22 December 2021

New Liverpool Primary School SSD 10391 – Request for Information

Attachment A – Detailed Responses

Drawing Title
SITE PLAN - PROPOSED

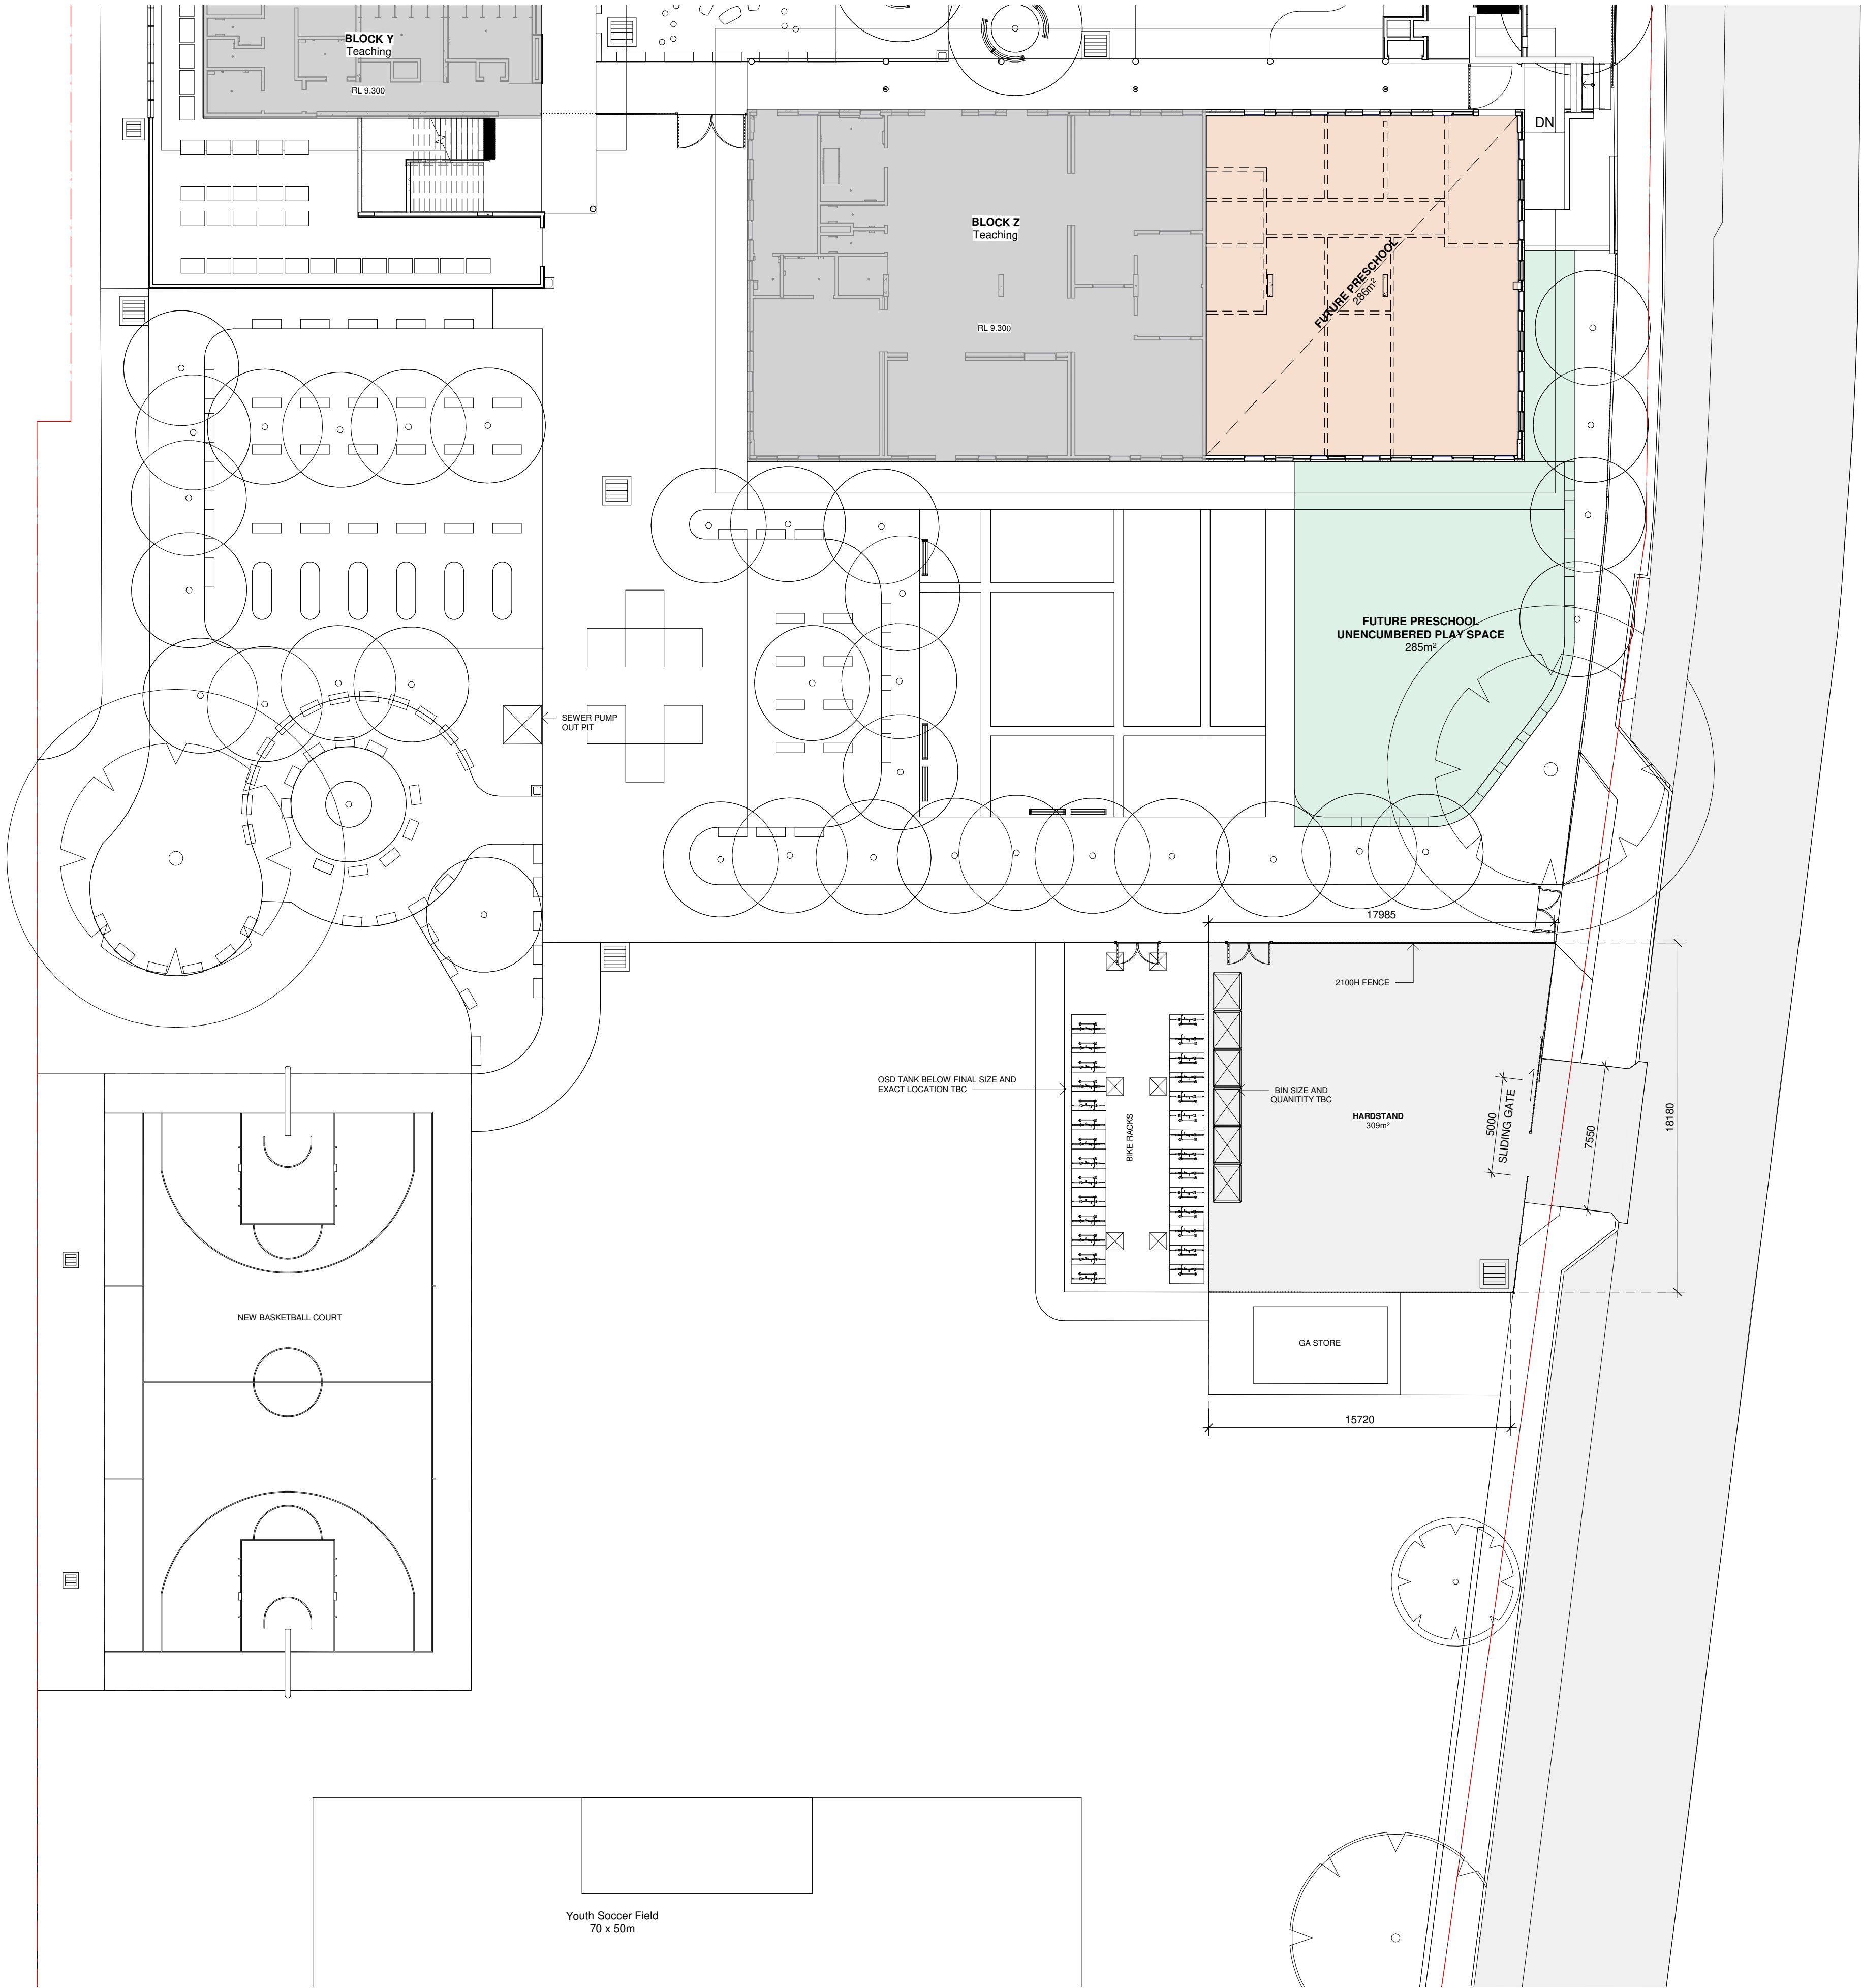
The Waste Hardstand Site Plan (Appendix K) includes details of a medium rigid vehicle (MRV) turning circle, which would access the site for waste collection in the future. However, the Department notes that the allocated hardstand space is not sufficient for MRV manoeuvring and that the MRV would encroach into the bike rack area and the ELC play area. Please address this issue and relocate/resize the hardstand area or relocate the vehicle turning circle area to allow for adequate manoeuvring of MRV within the site.	The hardstand area is part of a separate application that is still progressing through detailed design. The design has been modified by the architect and can accommodate waste vehicles turning around on site and therefore can enter and exit the site in a forward direction. Swept paths for waste vehicles is included at Attachment E.
The architectural plans show that the ground level is designed to be at Liverpool Central Business District (CBD) overland flow Probably Maximum Flood (PMF) level. The supporting report indicates that it is difficult to construct the building above this PMF and therefore a flood evacuation plan would be needed. The evacuation plan has not been submitted with the application. A preliminary flood report is required to be submitted for review, given the sensitive use of the site.	A preliminary flood report and emergency evacuation plan is provided at Attachment F which demonstrates an acceptable outcome can be achieved through its implementation and negates the need for finished floor levels which achieve Georges River Probable Maximum Flood.

Drawing Title
ELEVATIONS - BLOCK Y

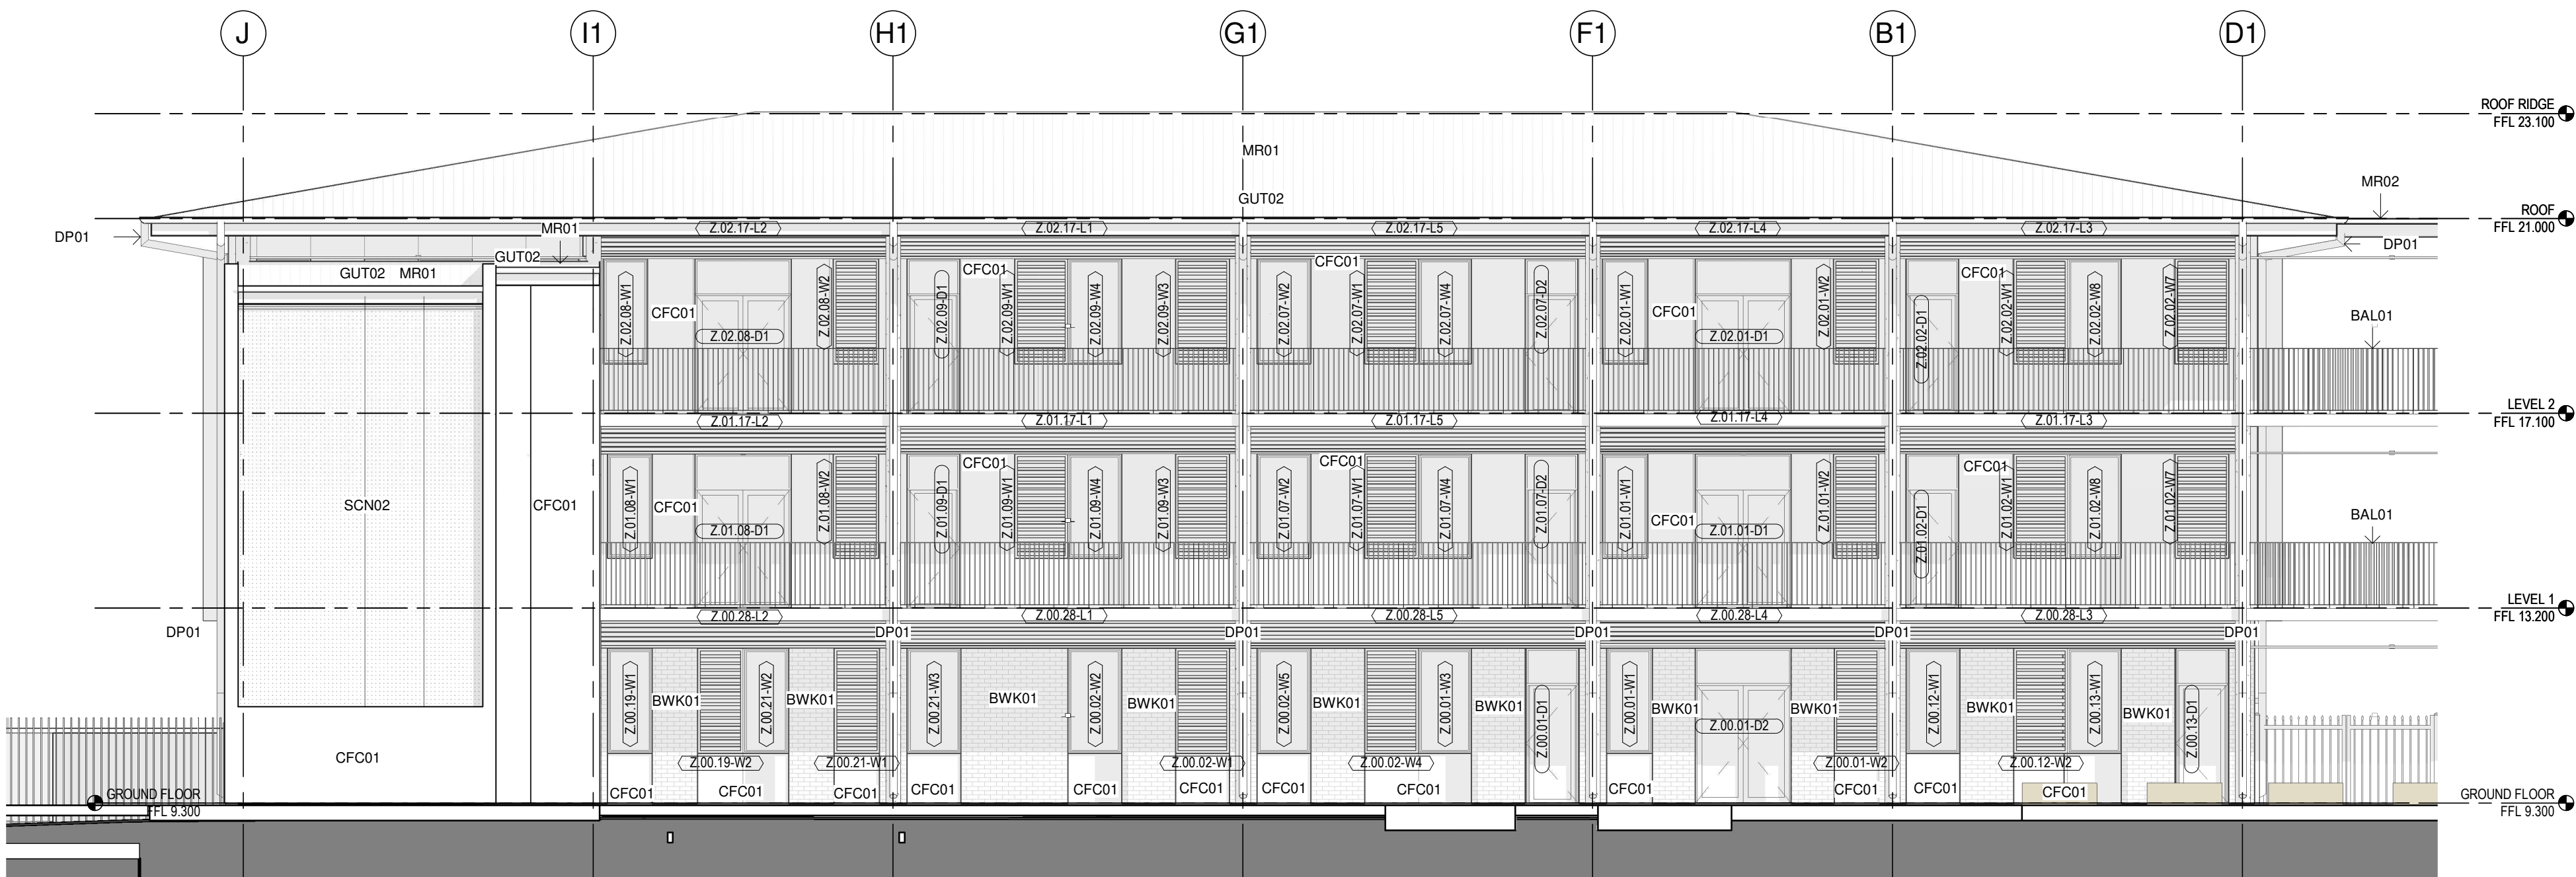
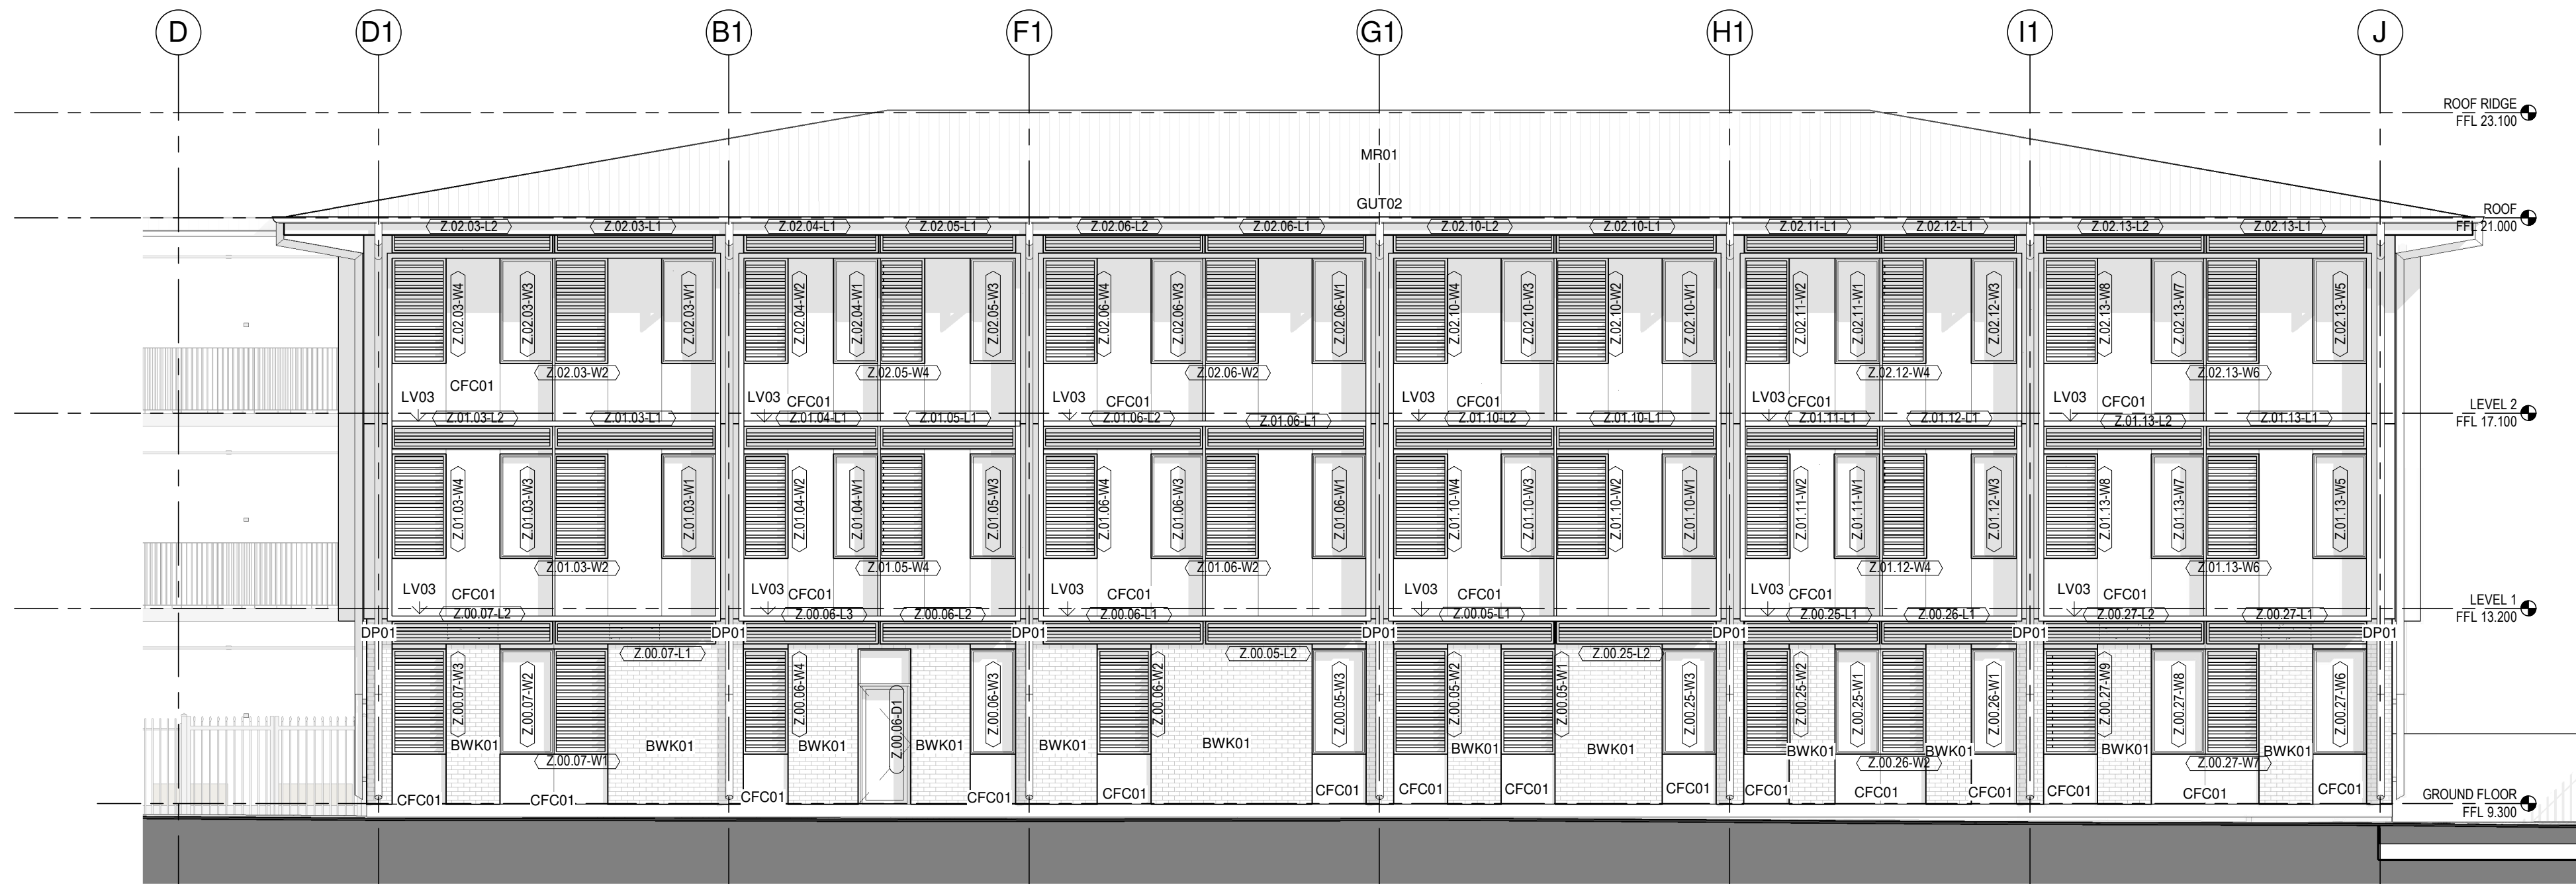
Comment	Response
The western façade should have additional external sun shading and drawings should be amended to include this feature.	Large shading devices which would effectively shade the Western façade are likely to compromise good levels of daylight, views, and ventilation. Therefore, instead of providing external sun shading, increased glazing performance is proposed, which will provide both high performance shading, as well as continued access to views, daylight and ventilation. This is discussed further by Steensen Varming at Attachment M .
The current bike parking location results in bikes being transported through the courtyard or the hardstand gate. The bike parking should be relocated closer to the student entry and away from the waste area to encourage a modal shift in the future.	Review of entry locations has been undertaken, including considering moving bike parking closer to student entry location. However, there are conflicting other services required in these locations that prevent this outcome further. SINSW prefer the bike storage area to be located further away from the courtyard. It is noted that the waste hardstand area will be fenced and separated from the bike parking area. The fencing strategy proposed to support this is provided at Attachment N and in the Landscape Drawings at Appendix C .
